Online Comment

Application H09-0034-17
Location Paddock between 1 Paddock Lane/Campling Place Holbeach Bank Spalding
Proposal Proposal of 56 new sustainable dwellings comprising 28 affordable homes and 28 open market homes together with provision of New Community Village Shop

Name Glen Chapman
Address Environmental Services South Holland District Council

Site Layout Plan

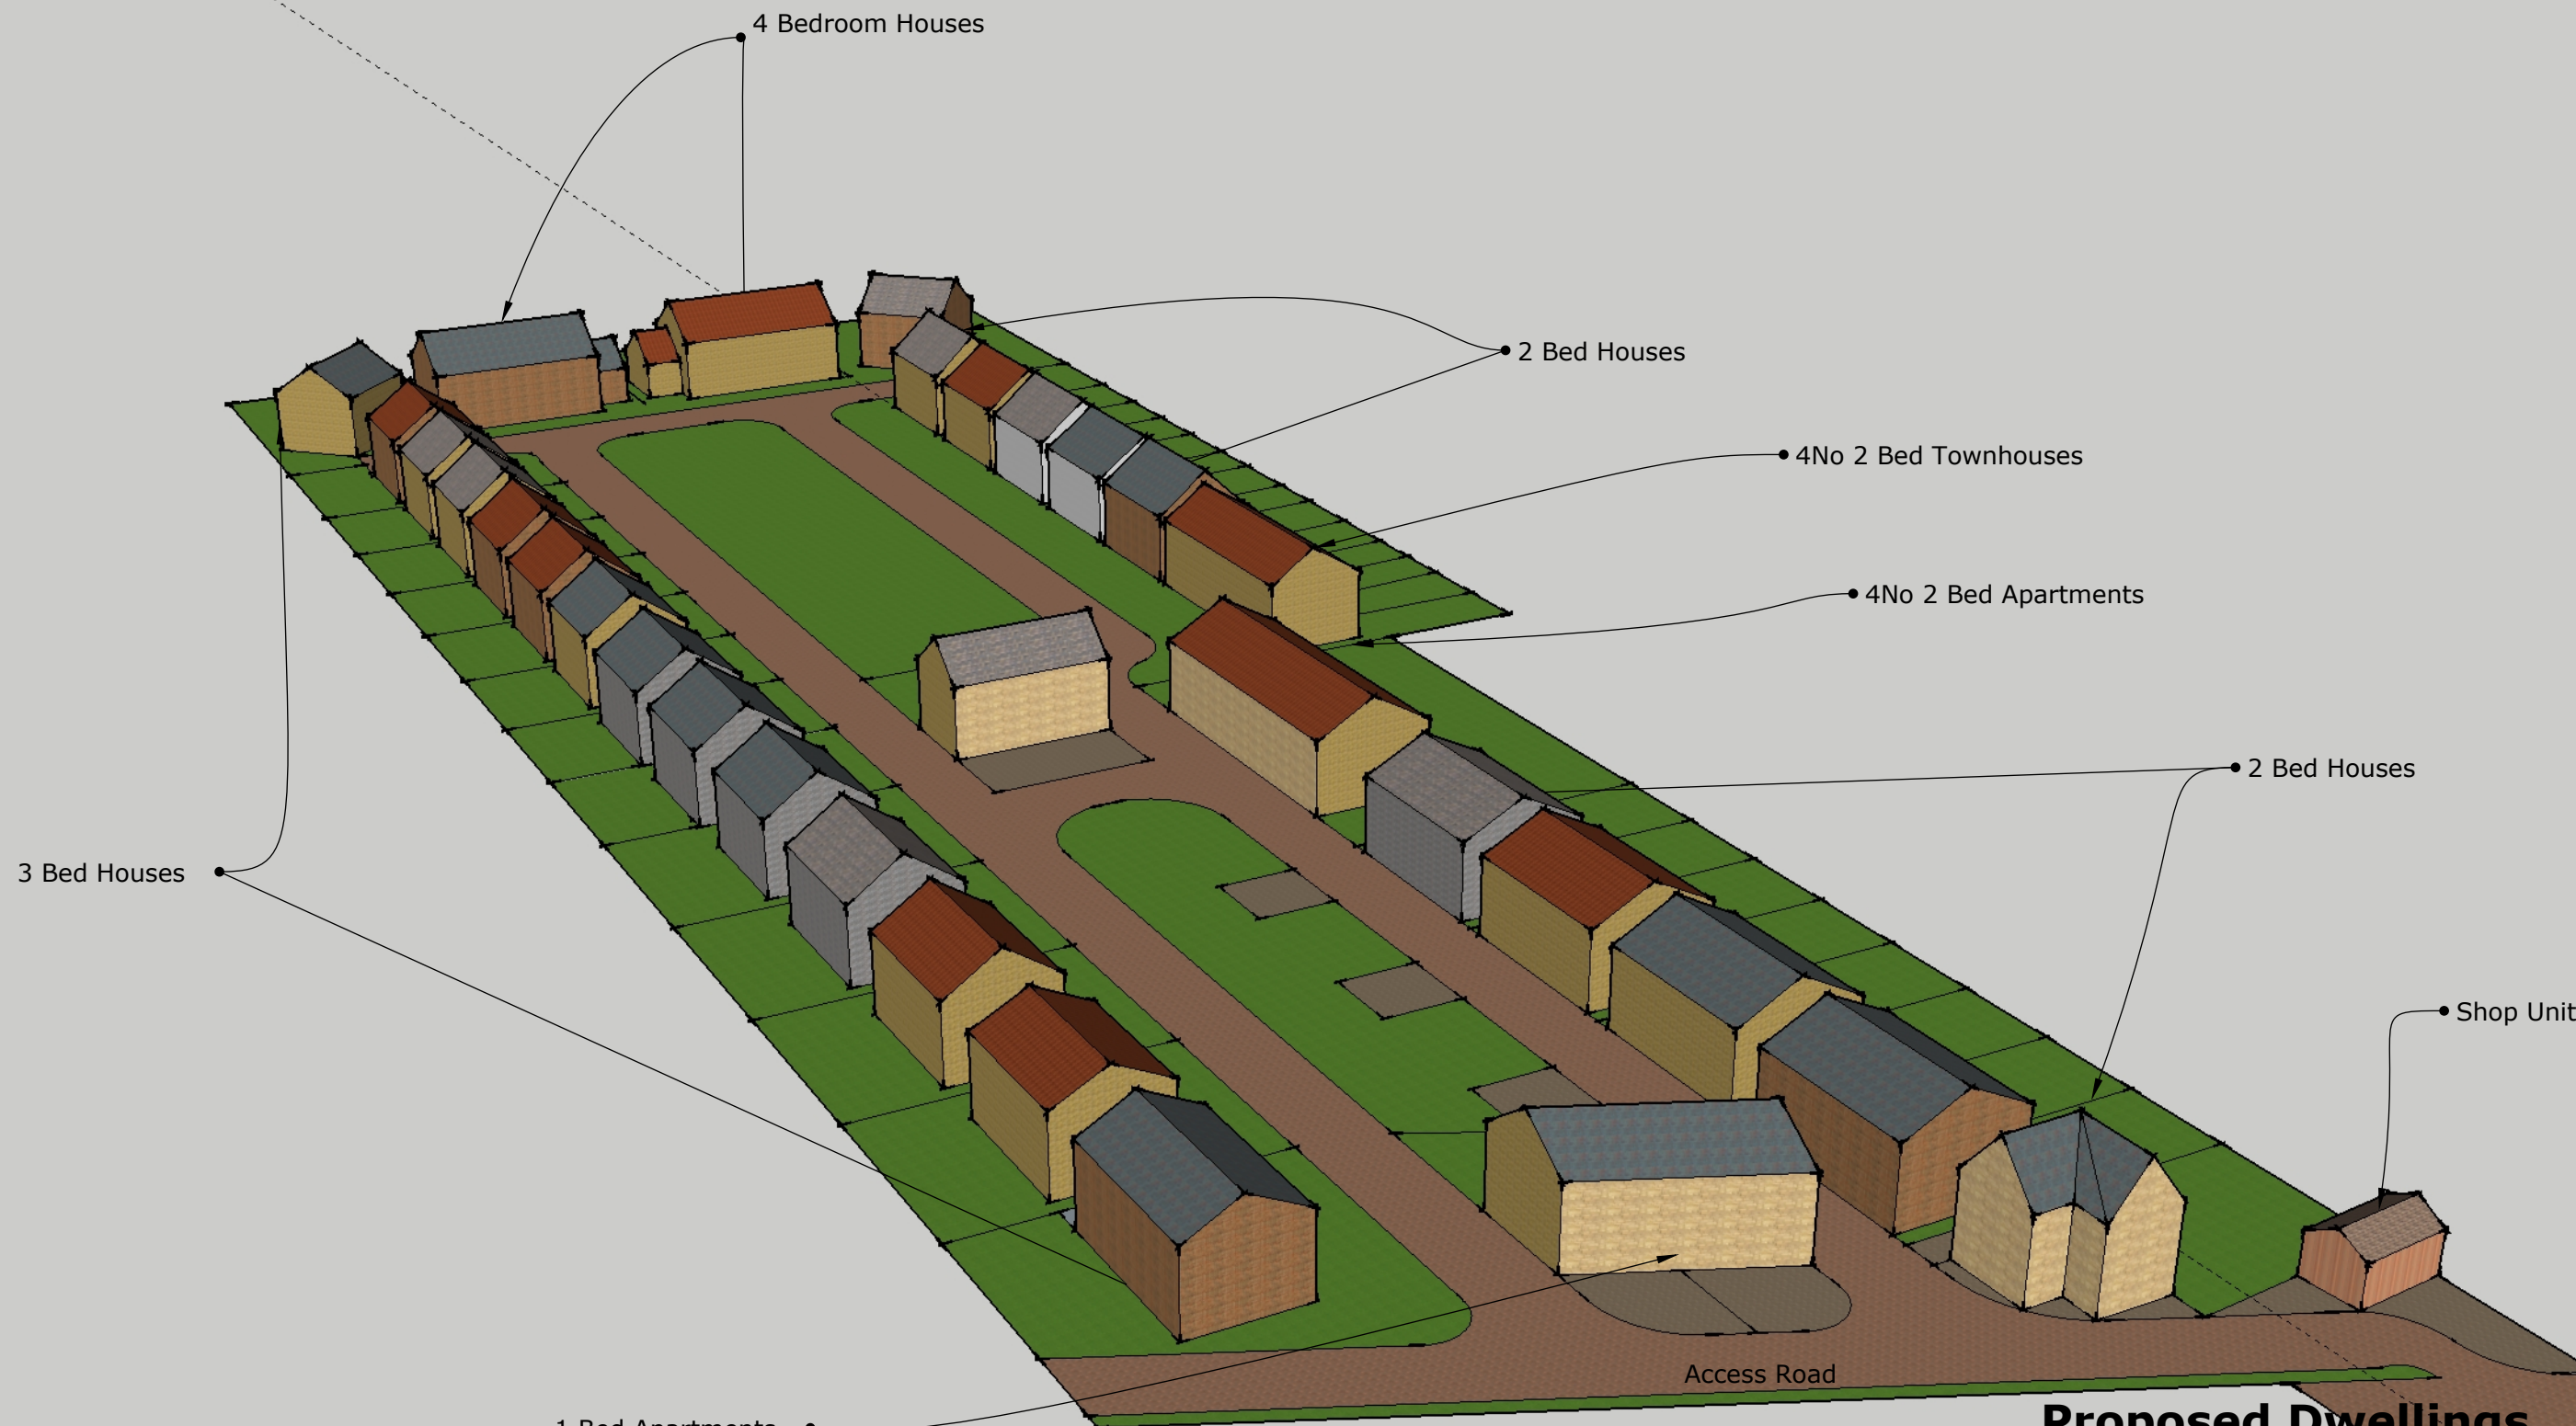
Access roadways to all residential properties should be constructed to an adoptable standard under an agreement with Lincolnshire County Council so that they will become public highways. This will enable refuse/recycling collections to be carried out from outside individual properties without the need for communal collection points at the point where private driveways adjoin public highways.

If not utilised correctly communal collection points become areas of dispute for residents of adjacent properties.

Should it be agreed that communal collection points will form part of this development the position of those collection points should be made clear to the potential occupiers of the properties nearby. This should not just be to the properties that will need to use the collection points but also the ones who will have them outside their properties.
